Our ref: RA/2022/145517/01
Your ref: EN010120
Date: 22 February 2023

DRAX POWER STATION BIOENERGY WITH CARBON CAPTURE AND STORAGE EXTENSION DEVELOPMENT CONSENT ORDER: WRITTEN REPRESENTATION

Appendix A – CEMP Watercourse Pollution Prevention Plan

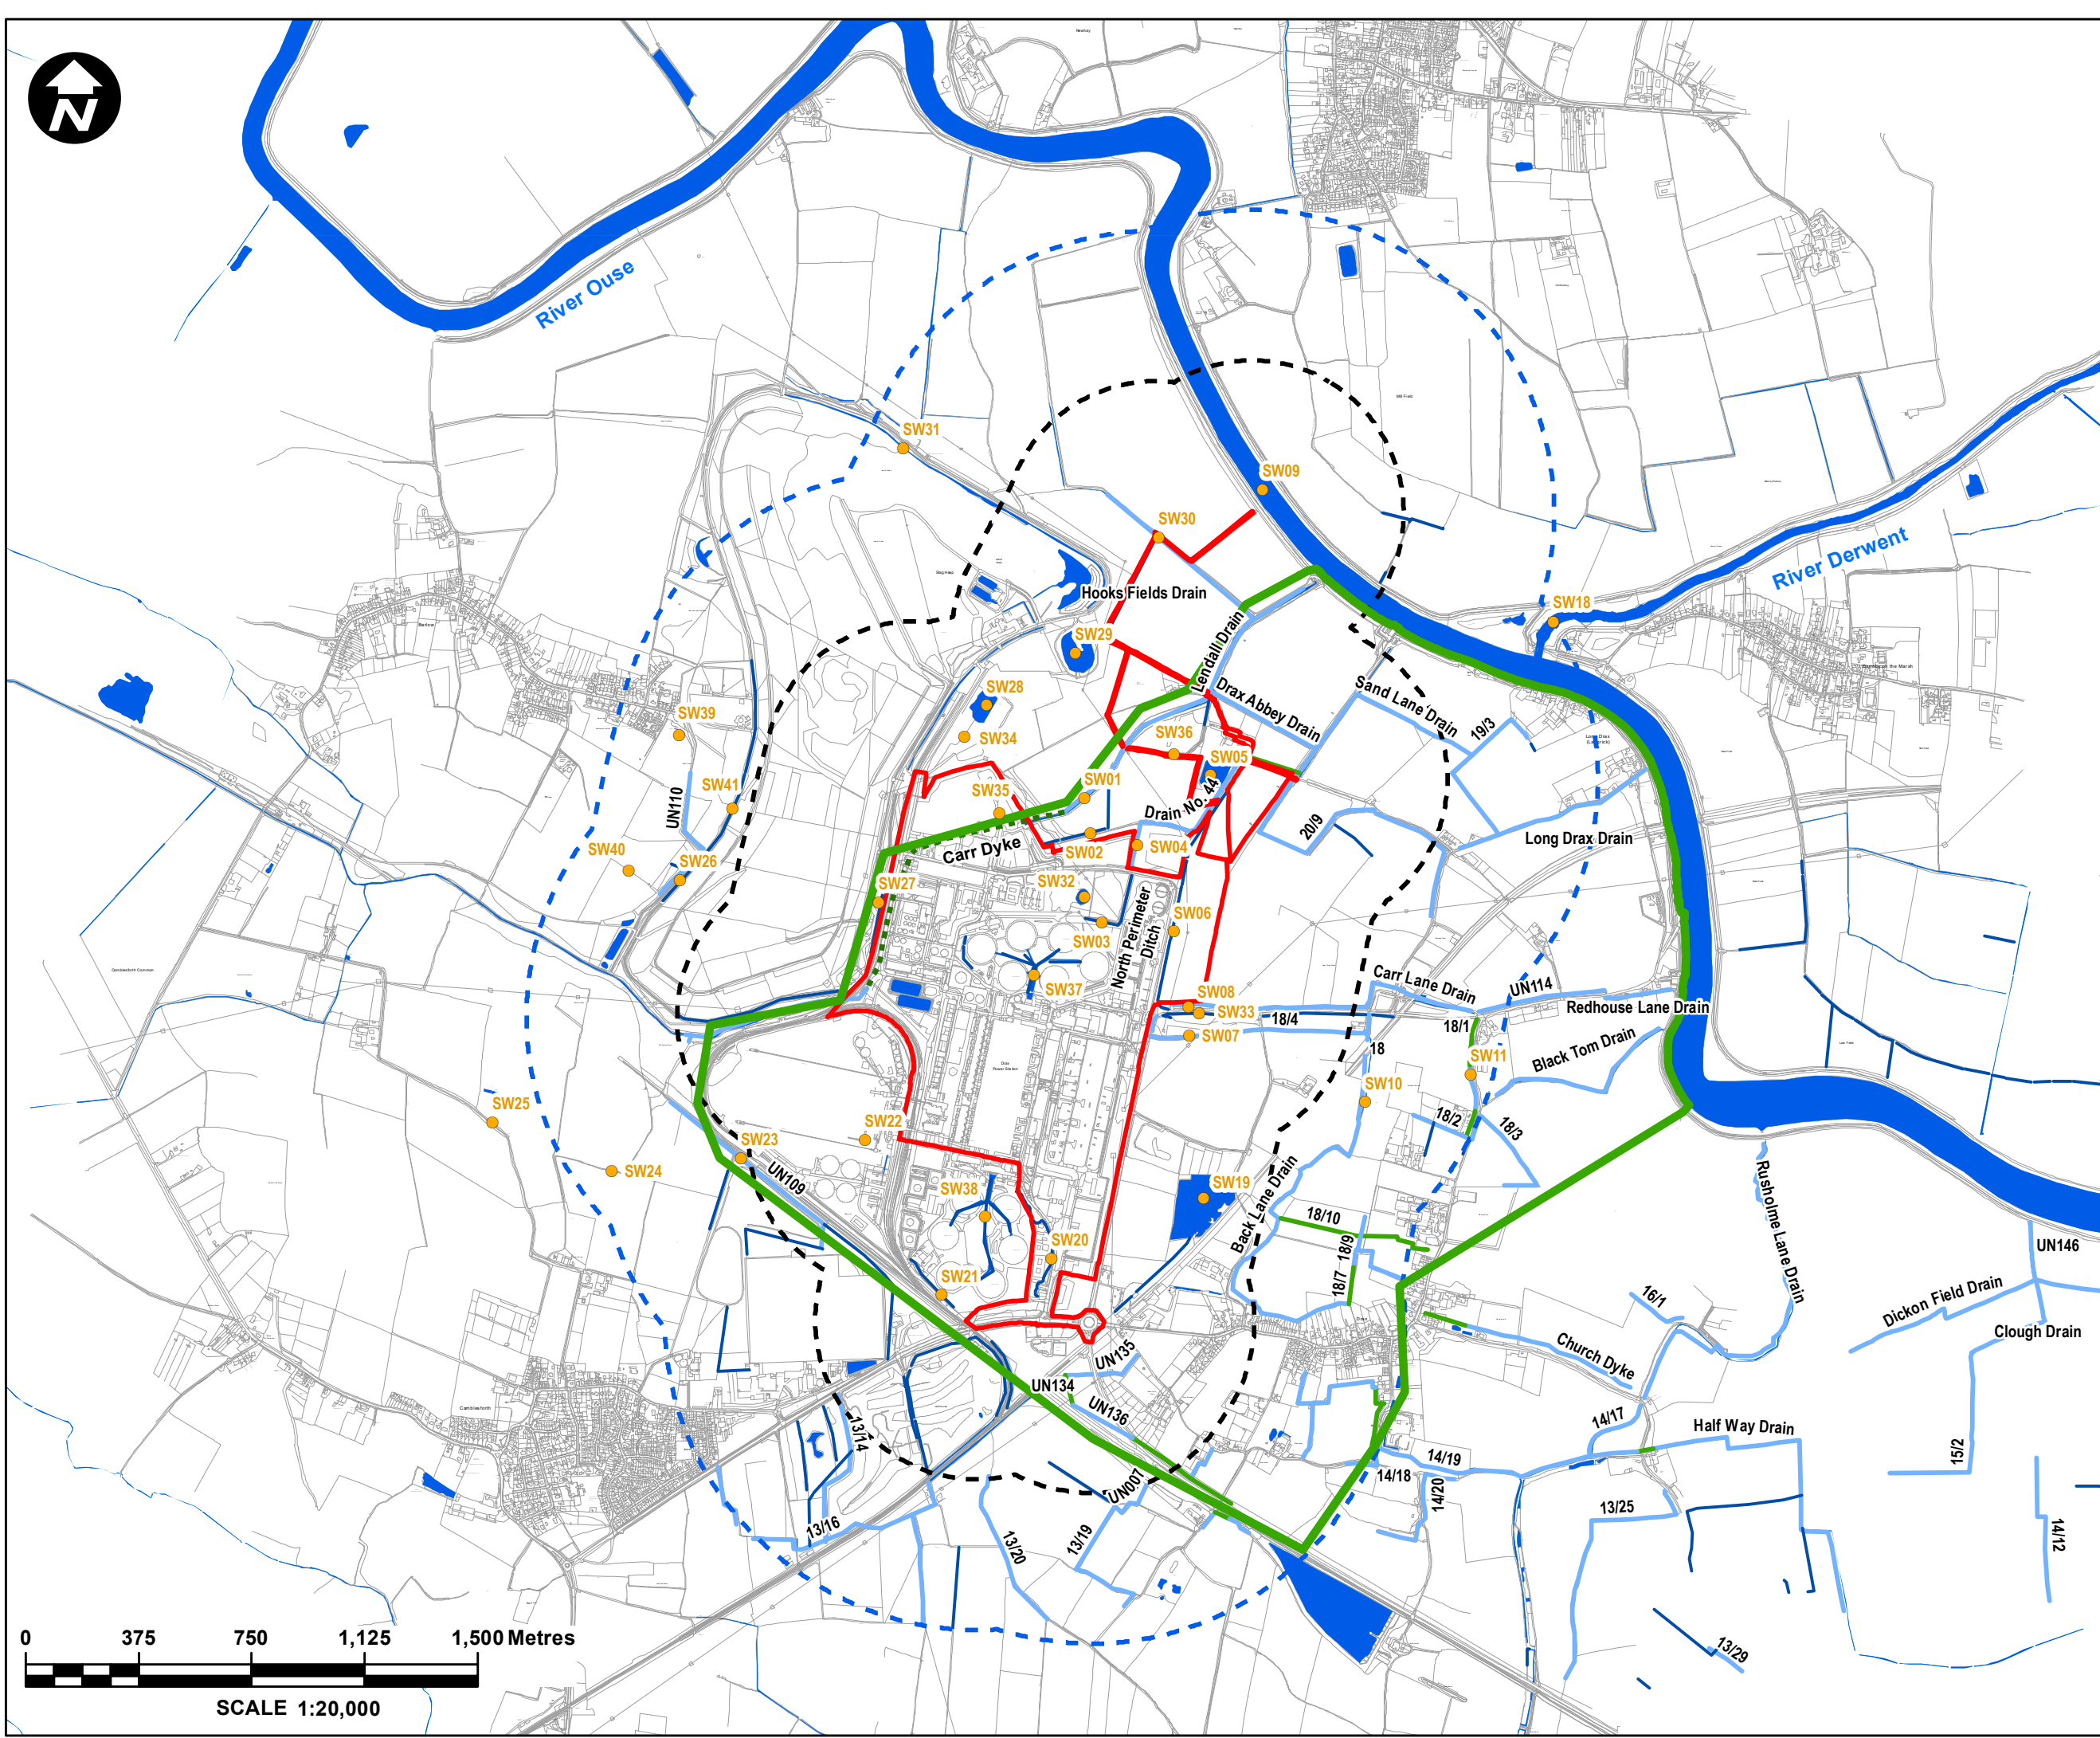
We welcome the plan in Appendix A which shows the CEMP Watercourse Pollution Prevention Plan boundary. Whilst this is in line with previous discussions we have had with the Applicant we wish to reiterate that included in the CEMP should be justification for any water features within the 500m buffer that are not within this boundary.
